November 3, 1997

RE: *ANTIQUE MALL (L22-D54). GRADING AND DRAINAGE PLAN FOR BUILDING PERMIT APPROVAL. ENGINEER'S STAMP DATED 10-13-97.*

Re: Antique Mall - Grading and Drainage Plan Revisions, (COA Drainage File No. L22/D53)

**RE: *ANTIQUE MALL (L22-D54). GRADING AND DRAINAGE PLAN FOR
FOUNDATION, BUILDING, GRADING AND PAVING PERMIT APPROVALS.
ENGINEER'S STAMP DATED AUGUST 27, 1997.***

GRADING AND DRAINAGE
PLAN

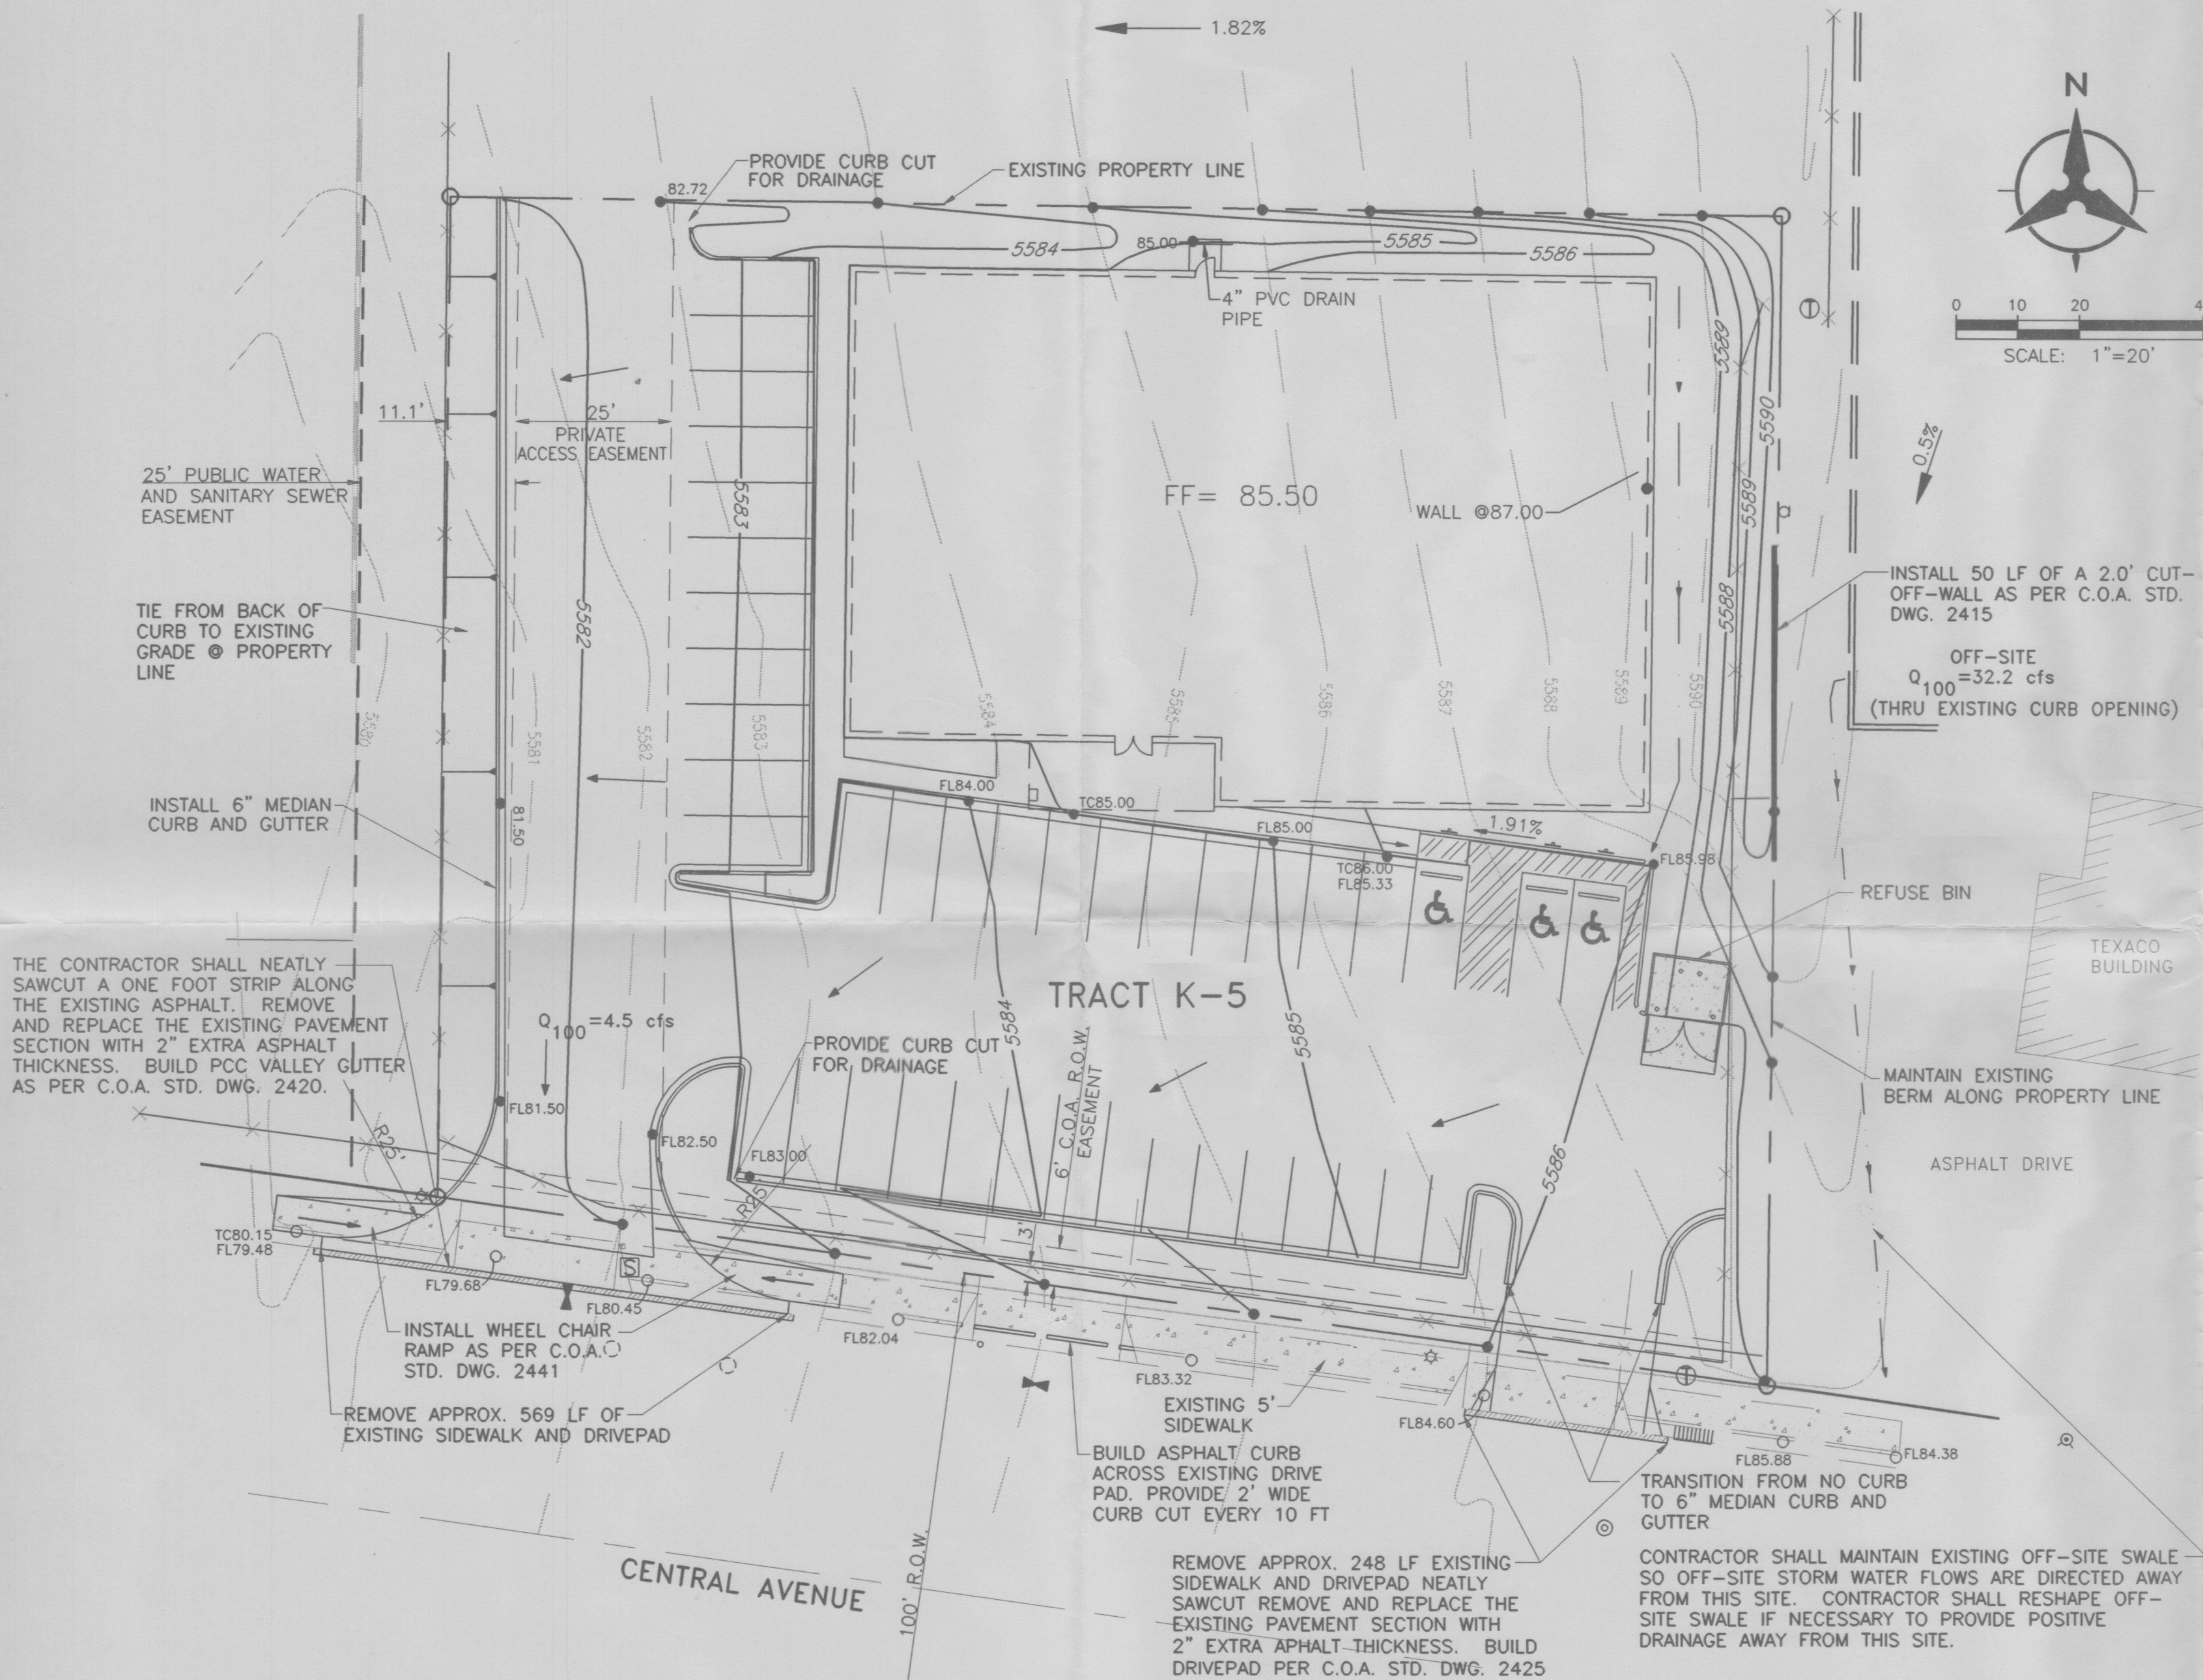
1. Provide grades on the east driveway. A one foot water block is required.
2. The grade on the west drive may be too steep. Check with the Transportation Division.
3. I assume that free discharge is allowed from this site. Please submit relevant information from the approved master plan demonstrating allowable discharge.
4. Provide relevant information from the approved master plan that discusses the re-routing of offsite flow.

As requested, I have provided grades on the east driveway. The elevation of the driveway at the right-of-way line is at least one foot above the flow line. This driveway allows storm water to flow into Central Avenue.

I have lowered the west drive entrance so that it does not exceed four percent (4%). A curb along the west side of the drive provides the necessary protection from flows in Central Avenue.

I referenced the Drainage Master Plan in my first submittal. It is hard to find but you can find it located in the notes section of my discharge tables. The approved **Master Drainage Plan for Tract K, Canyon Acres Development** was prepared by Jeff Mortensen & Associates, Inc. Engineer's stamp dated March 6, 1995 allows for free discharge. The DMP information was provided with COA Project #5227.90. I am enclosing a copy of this with this letter.

As shown on the grading plan, the natural (or existing) contours along the eastern boundary indicate that the off-site flows were, at one time, routed along the boundary toward Central Avenue through TEXACO's driveway. The flow is quickly intercepted by a type "C" double grate inlet in Central Avenue just beyond the TEXACO drive pad.

After visiting the site, it is apparent that the existing berm along this boundary has been breached and now allows flows to cross the site. We propose to re-establish the pervious routing by providing curb and gutter and pavement which will direct off site flows along the eastern boundary.
